SEARs for MLC Burwood Senior School Centre (SSD 6484) 45 Park Road, Burwood

Secretary's Environmental Assessment Requirements

Application Number	SSD 6484
Proposal Name	MLC Burwood Senior School Centre
Location	45 Park Street, Burwood
Applicant	MLC School
Date of Issue	14 May 2014
General Requirements	The Environmental Impact Statement (EIS) must meet the minimum form and content requirements in clauses 6 and 7 of Schedule 2 the <i>Environmental Planning and Assessment Regulation 2000</i>. Notwithstanding the key issues specified below, the EIS must include an environmental risk assessment to identify the potential environmental impacts associated with the development. Where relevant, the assessment of the key issues below, and any other significant issues identified in the risk assessment, must include: • adequate baseline data; • consideration of potential cumulative impacts due to other development in the vicinity; and • measures to avoid, minimise and if necessary, offset the predicted impacts, including detailed contingency plans for managing any significant risks to the environment. The EIS must be accompanied by a report from a qualified quantity surveyor providing: • a det

SECTIONS 1

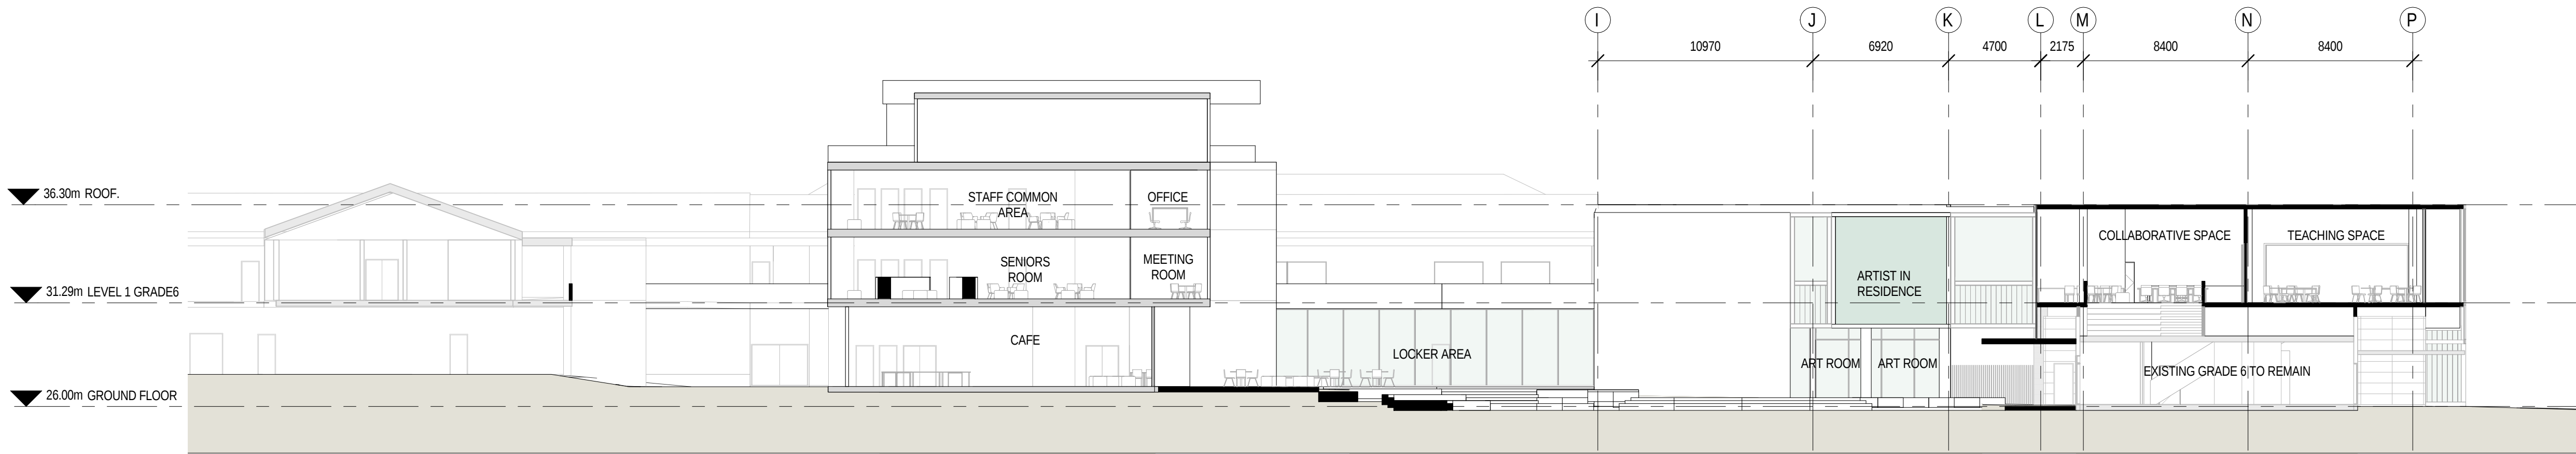
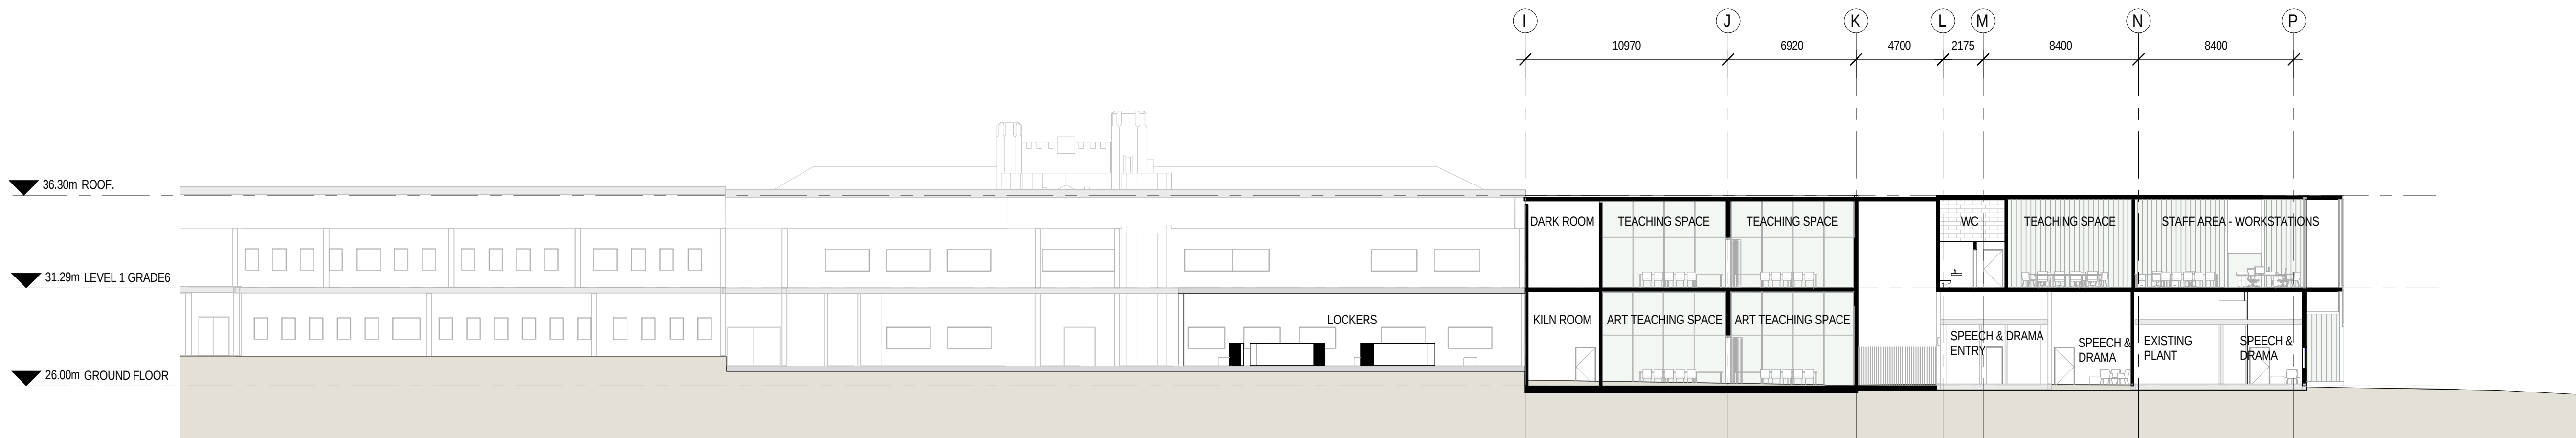
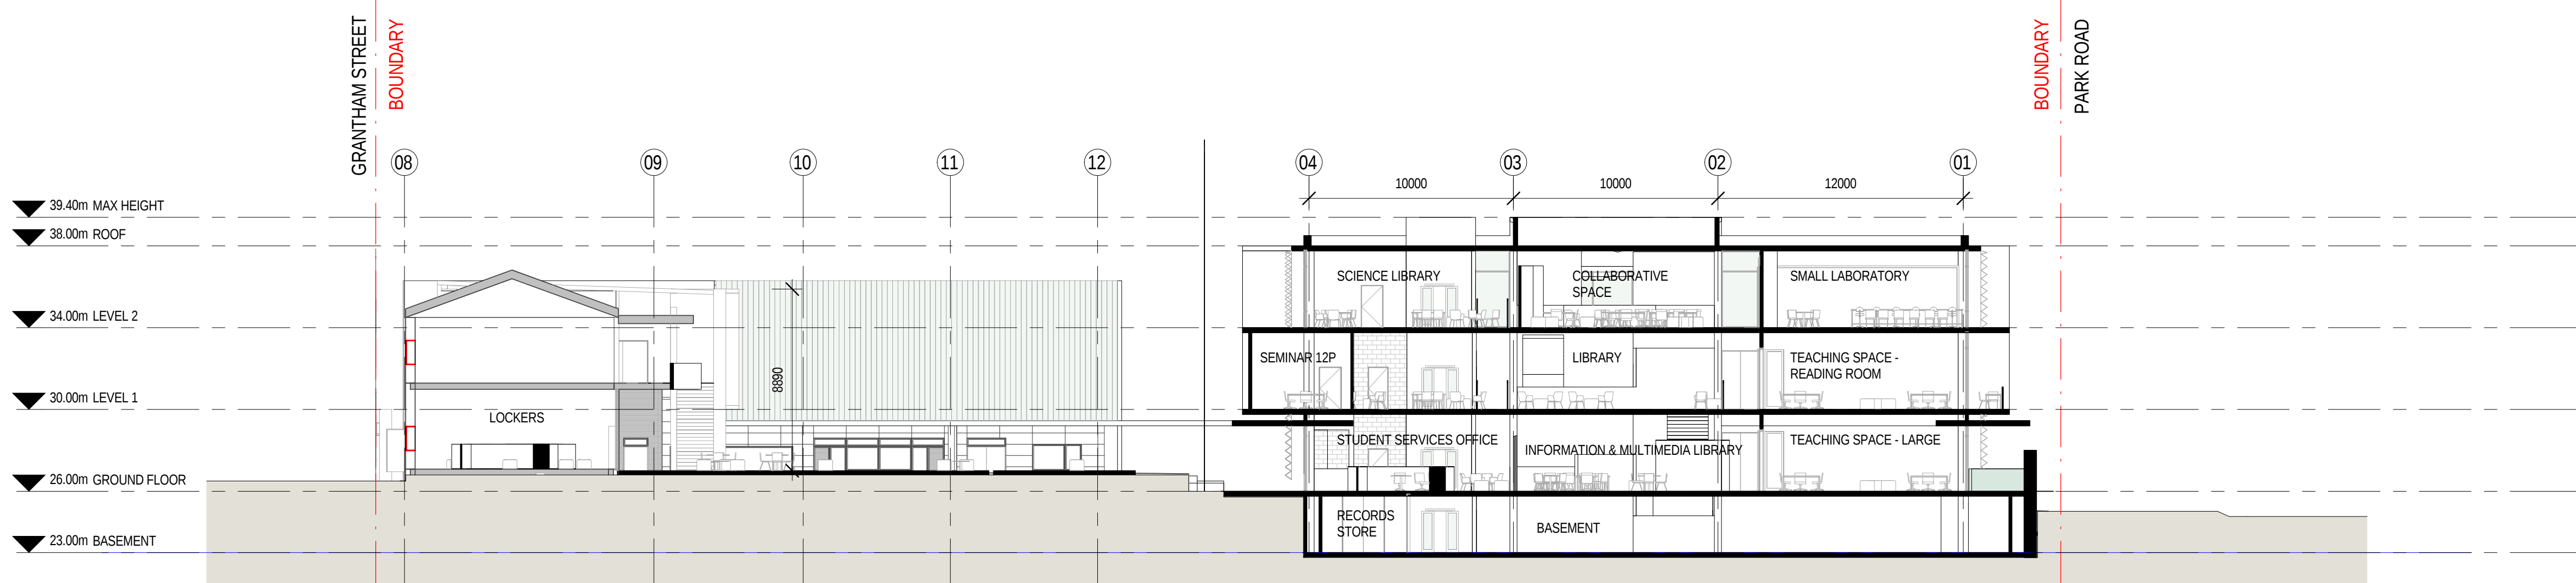
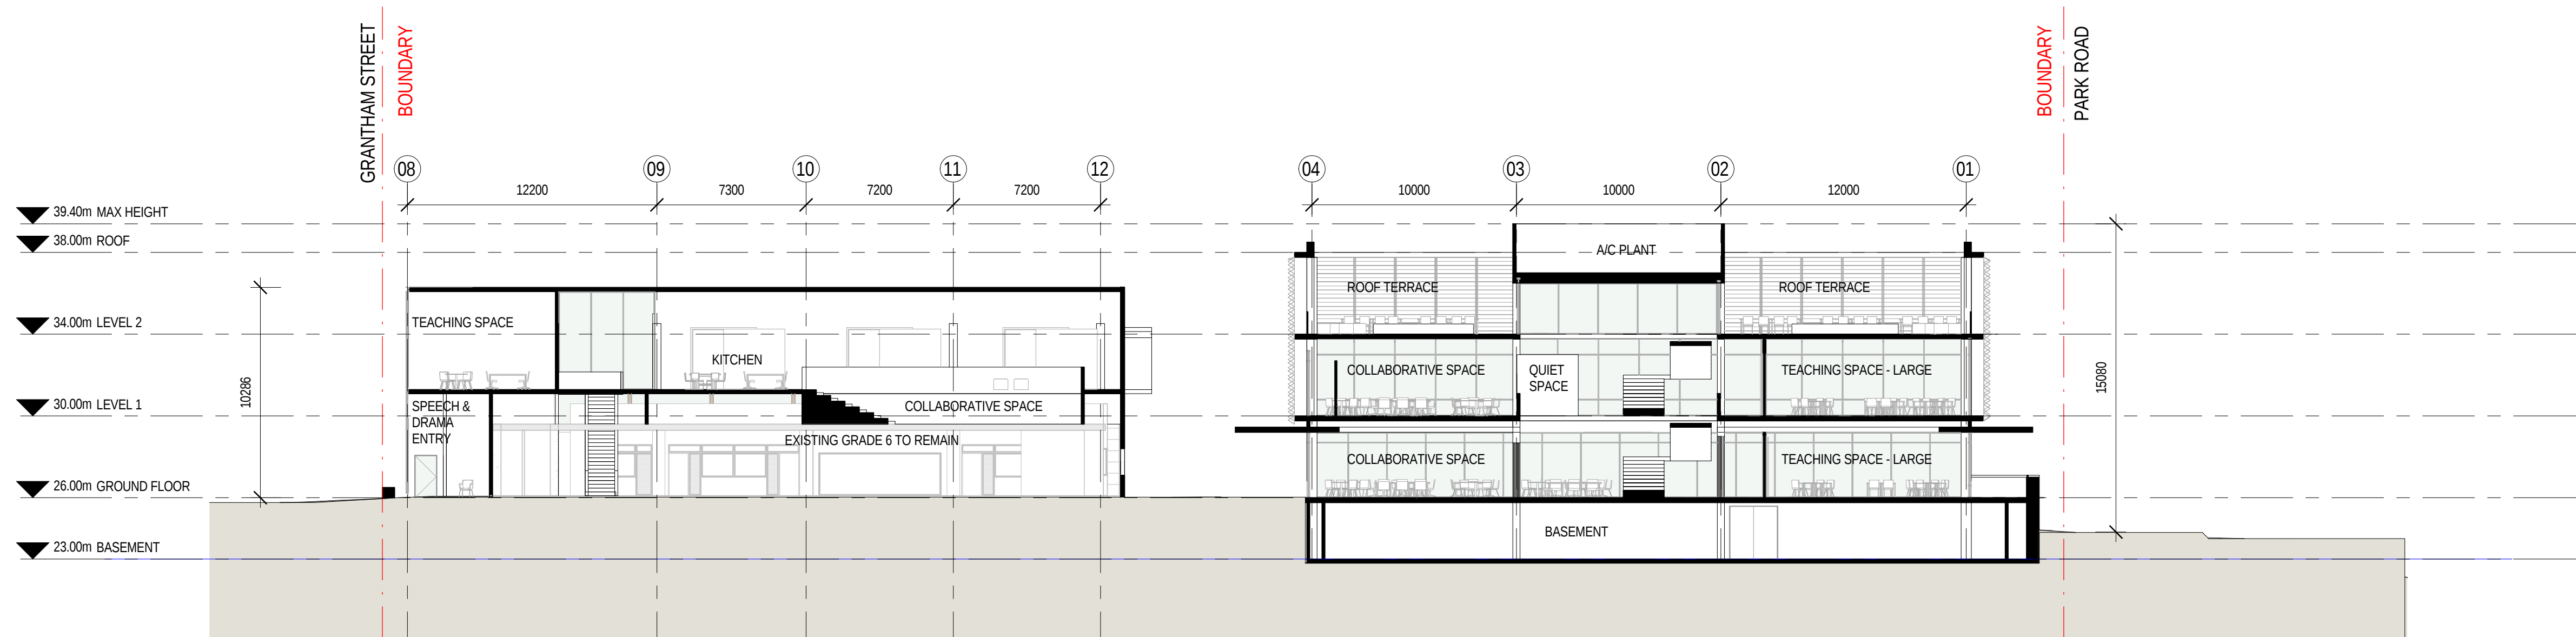
- The maximum height limit in the R2 zone is 8.2m. This limit is most relevant to residential scale development that predominates in this zone.
- It is noted from your Pre-DA documentation that existing buildings on the site already exceed this limit. Building work outlined in the Pre-DA will as well, but new development is proposed to not exceed the height of existing buildings.

- The application will need to include a request and present a case under Clause 4.6 of the BLEP for departure from the maximum height limit standard. Responses to public notification of the application will be relevant to Council's assessment of the building height issue.
